Charlotte Storm Water
600 East Fourth Street
Charlotte, N C 28202-2844

Rezoning Petition Review

Date of Review: February 24, 2020 (***Revised March 23, 2020***)

Rezoning Petition #: 20-25

SHEET NUMBER  
**RZ-1**

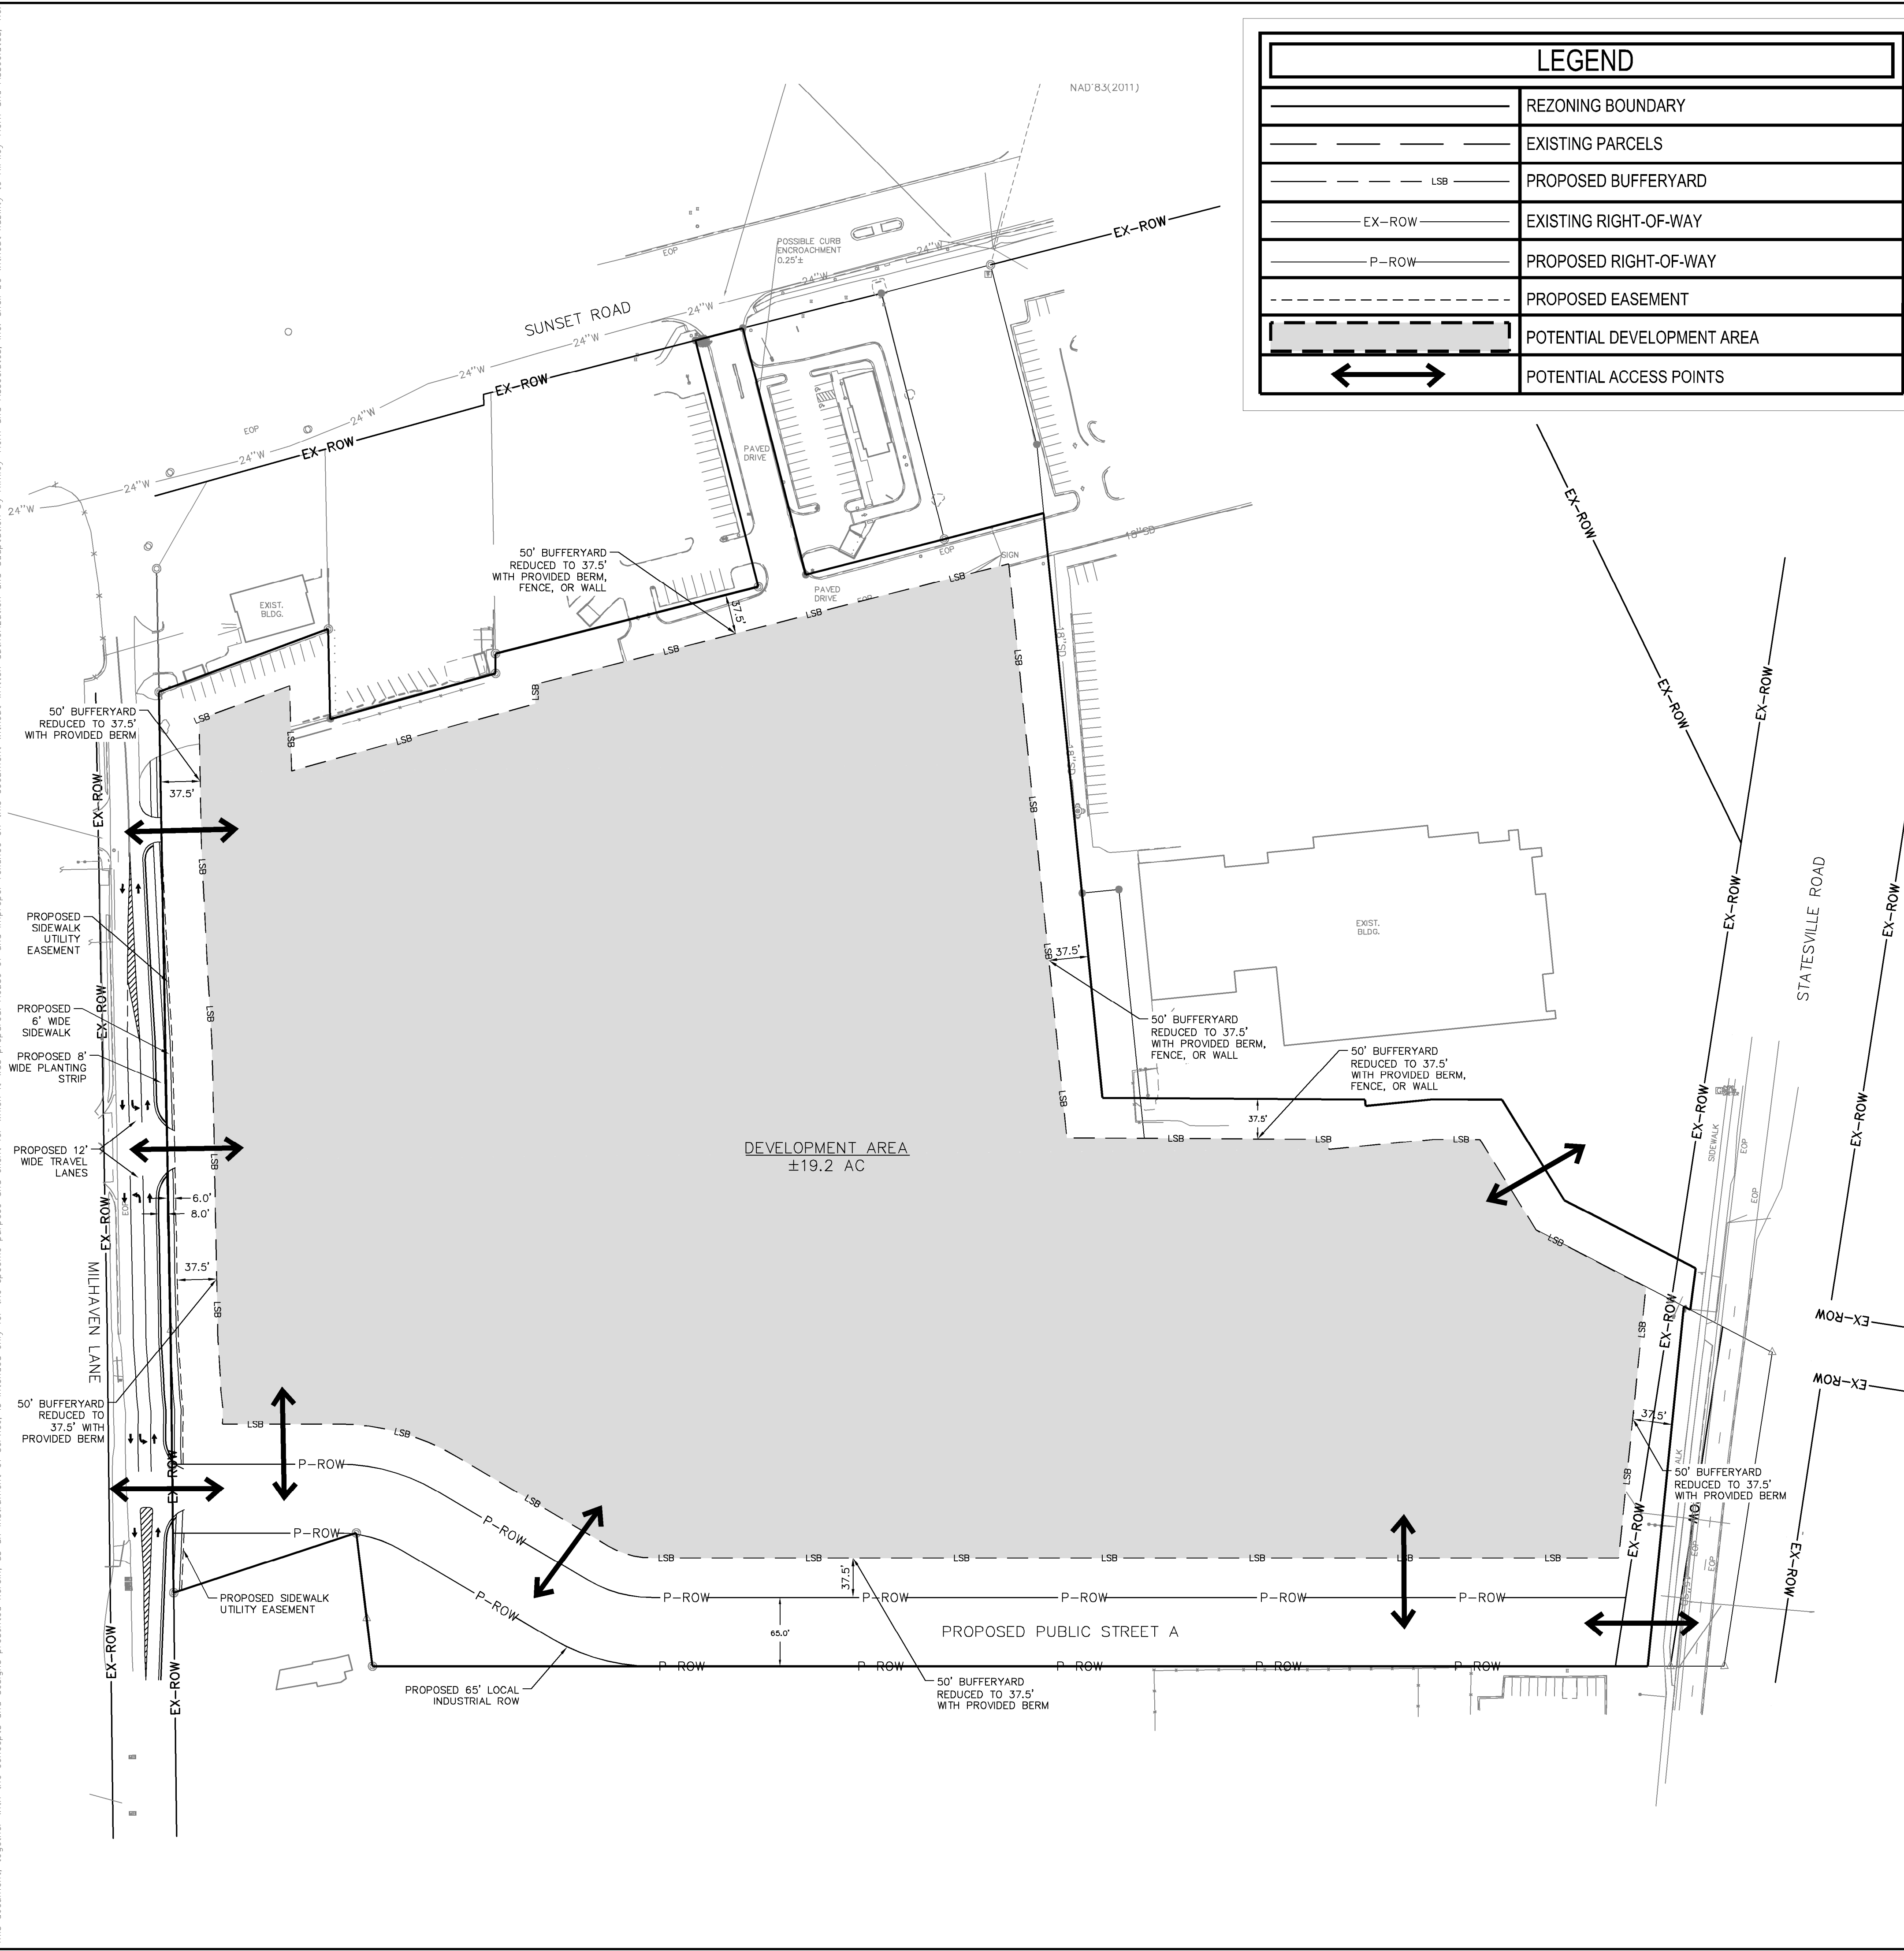
Concerning Storm Water: City of Charlotte GIS data indicates a 30-ft PCSO buffer across the site. Please show and label *Potential 30-ft PCSO Buffer* on the site plan. Any increase of impervious area within such buffers may not be allowed and is not approved with the rezoning process. Stream Delineation Reports are subject to review and approval by Charlotte Storm Water Services. Please include the following note under Environmental Features: *"Development within any SWIM/PCSO Buffer shall be coordinated with and subject to approval by Charlotte-Mecklenburg Storm Water Services and mitigated if required by City ordinance."*
